DECISION DELEGATED TO HEAD OF PLANNING

Application No: H05-0250-22 **Applicant:** Mr J Sidebottom
Proposal: Proposed front extension, detached single garage and connecting carport
Location: 2 Greenfields Holbeach Spalding
Terminal Date: 3rd May 2022

PROPOSED FRONT ELEVATION

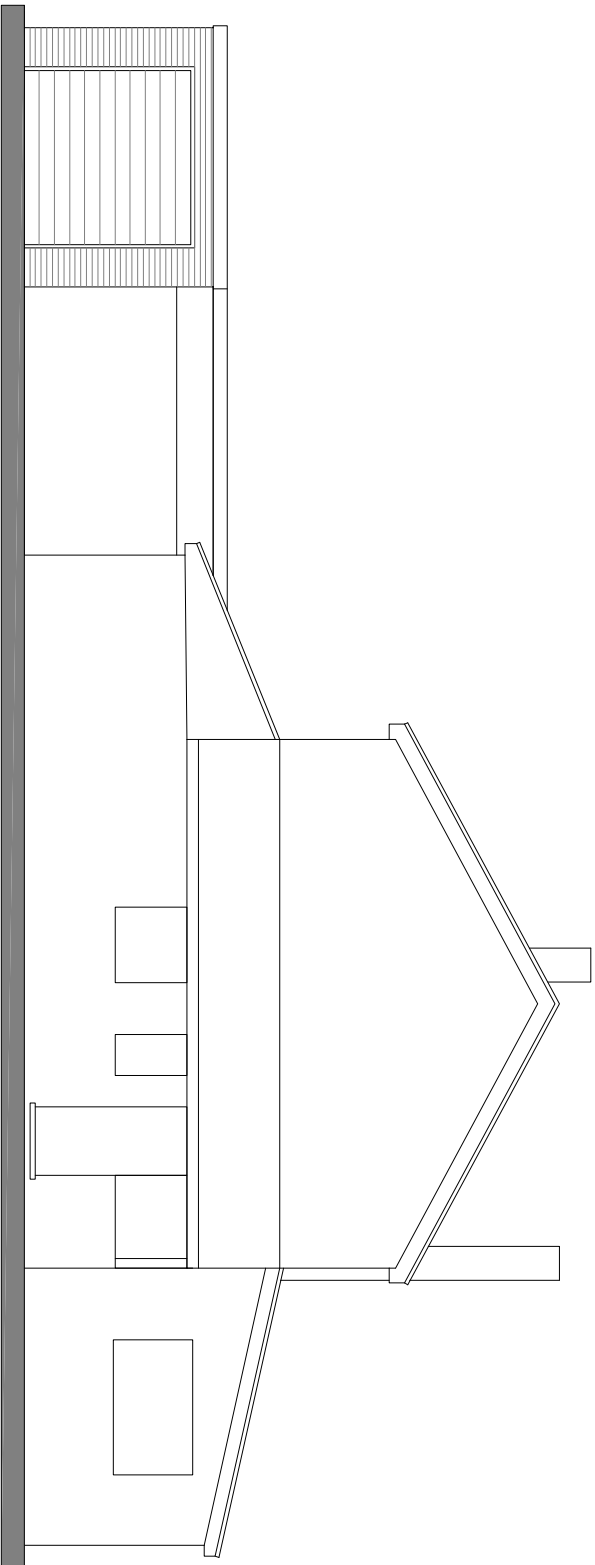
The proposed music room extension is considered a minor addition which is in keeping with the existing dwelling. The use of matching external materials would ensure it is in keeping with the existing dwelling.

The immediate street scene is characterised by detached dwellings set back from the highway by at least 5 metres. The proposed garage and carport to the front of the site would be sited right next to the front boundary adjacent to the highway. There is a strong built form in the street with no such structures located to the front of the dwellings. Having regard to the pattern of existing development in the vicinity and location of the site, the proposed front projecting garage and carport are considered to be out of keeping with the character and appearance of the surrounding area and they would appear overly prominent and visually intrusive in the street scene.

PROPOSED GARAGE ELEVATIONS

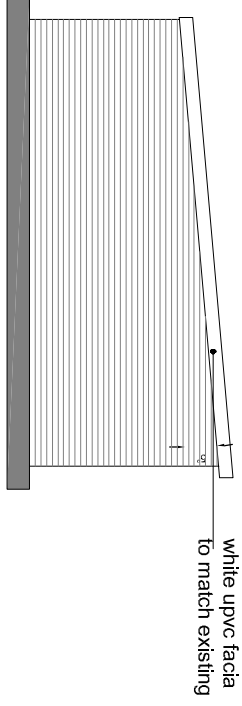
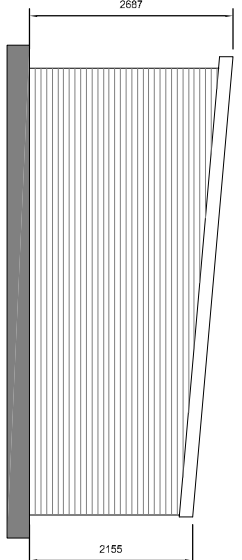
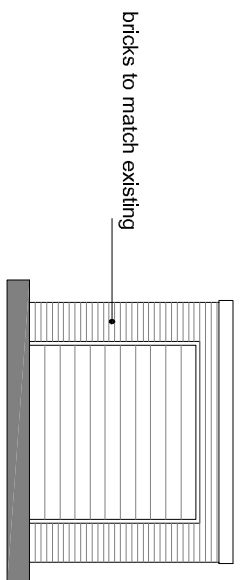
In connection with Policy 36 of SELLP 2019, Appendix 6 sets out the minimum requirements for car parking provision. The proposed garage measures only 5.5 metres in length internally therefore this does not meet the size requirements for enclosed parking spaces. However, the proposed carport can be considered a formal parking space and 2-3 further vehicles can be accommodated in the driveway. As such the site meets the current parking standards as a maximum of 3 no off-street parking spaces are required for the site.
